Our ref: NO/2015/107923/02-L01
Your ref: 3/2015/0462
Date: 29 September 2015

**DEMOLITION OF INDUSTRIAL STORAGE BUILDINGS TO THE REAR OF 19-21 KING STREET AND REGENERATION OF THE SITE TO PROVIDE 3 NO. TWO-STOREY DWELLINGS - ONE DETACHED AND ONE PAIR OF SEMI-DETACHED (FRA PROVIDED)
19-21 KING STREET, WHALLEY**

3980 - 04A.

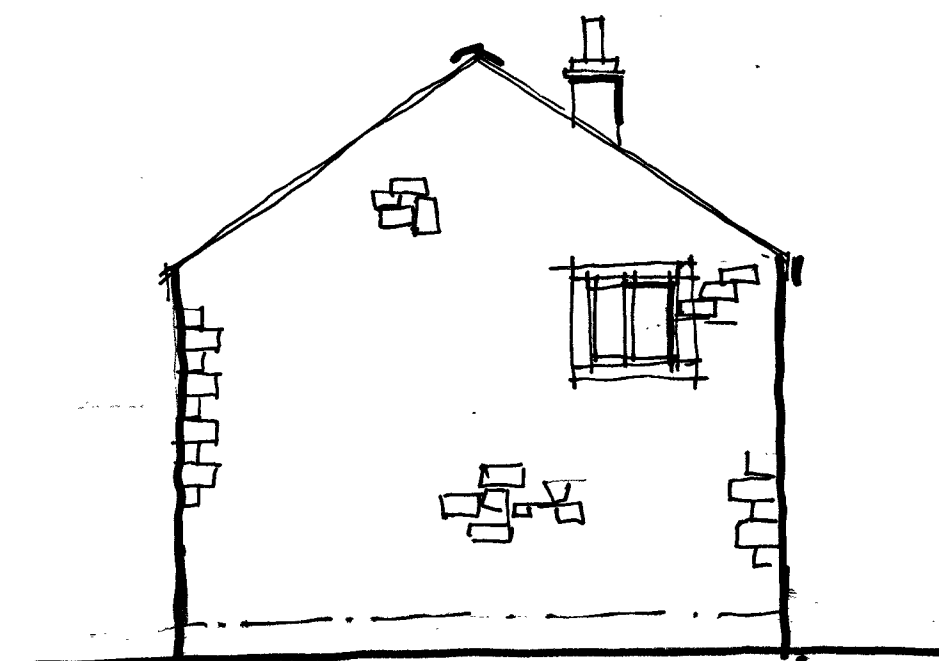
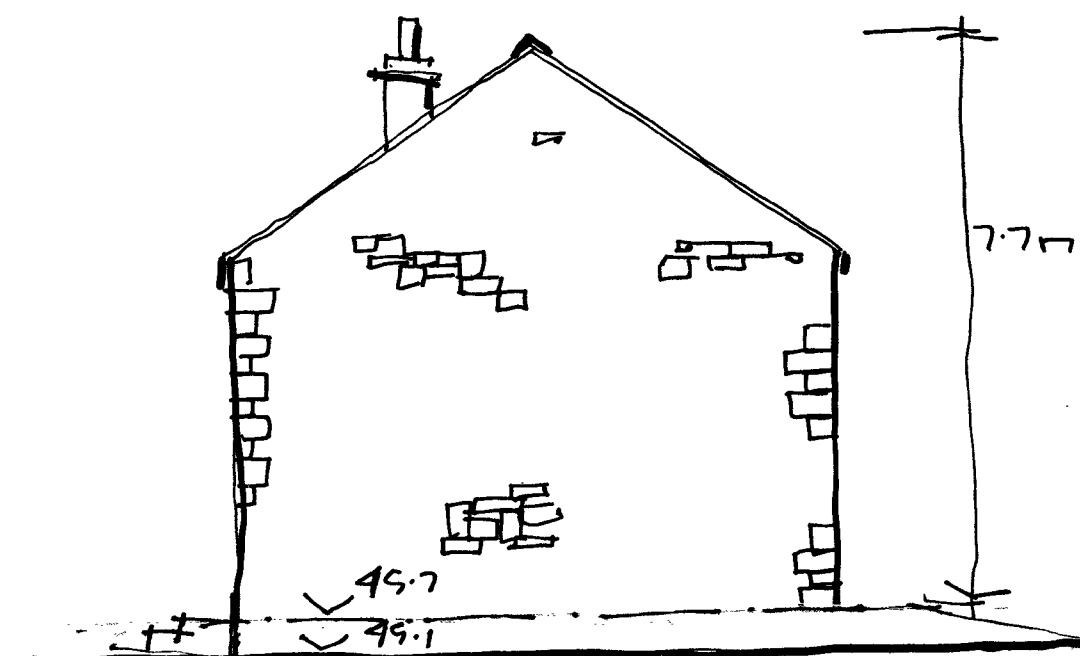
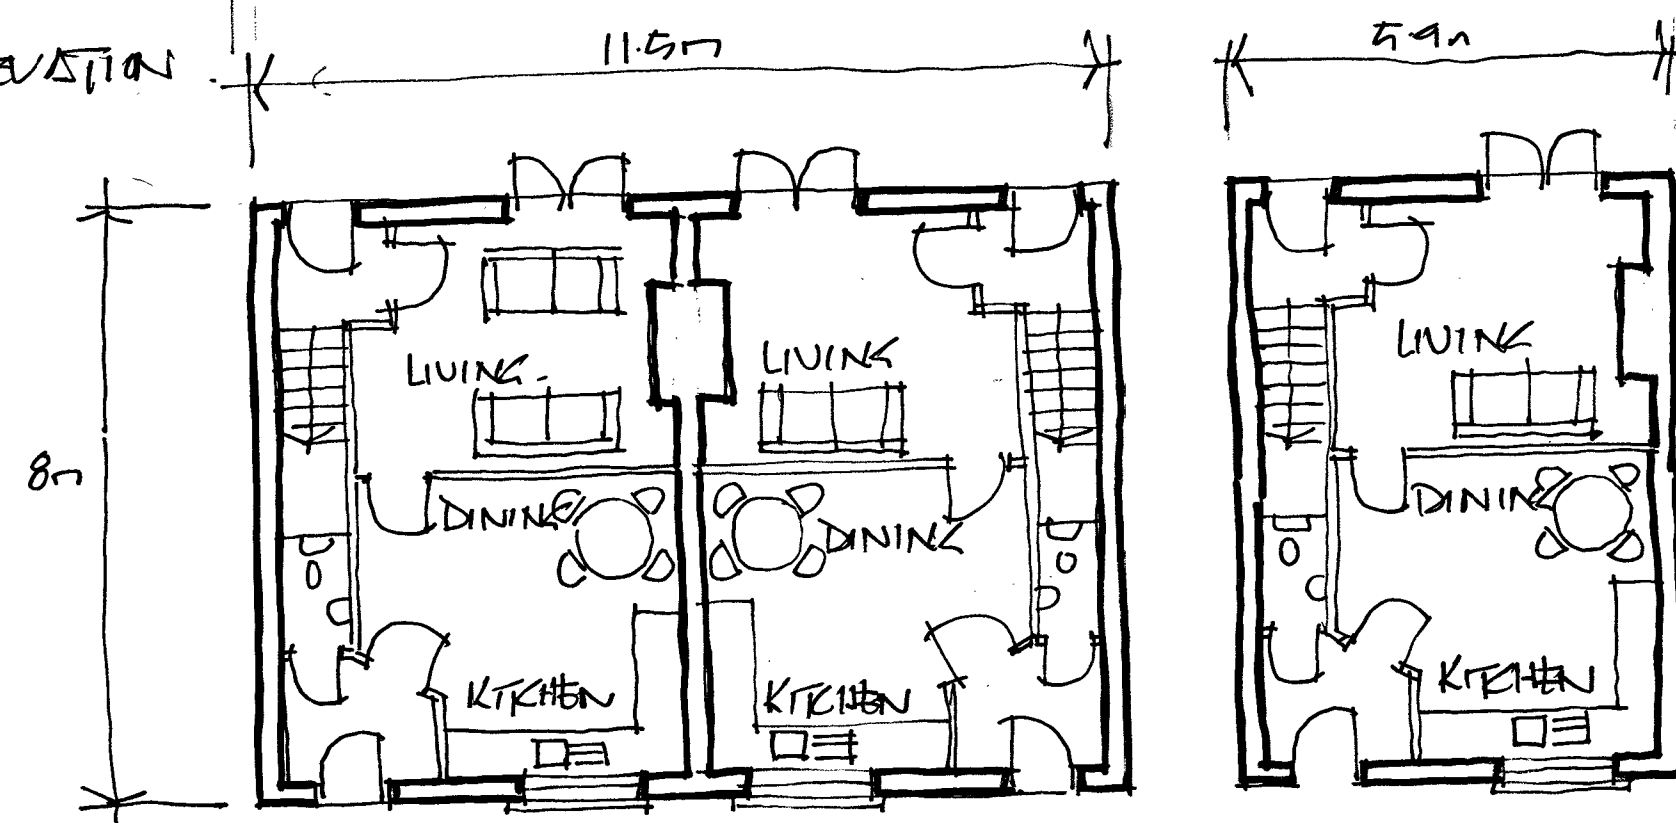
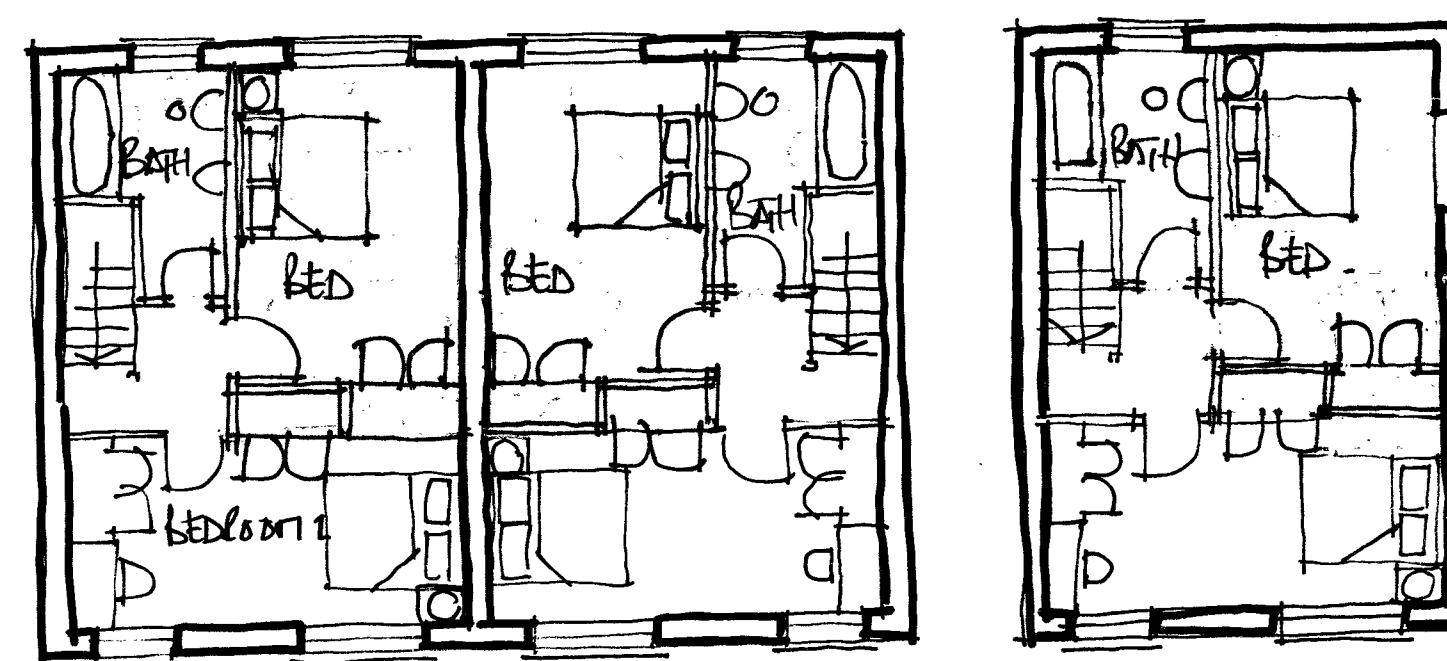
1. Existing and proposed floor levels are not shown in metres above Ordnance Datum (mAOD), but are simply shown as arbitrary numbers which we are unable to condition.
2. A proposed finished floor level is not clearly shown. Instead, the FRA advises two different floor levels. Finished floor levels should be set at least 600mm above existing ground levels, and be referred to Ordnance Datum
3. The proposed building needs to have a solid floor and be constructed from flood resilient materials.
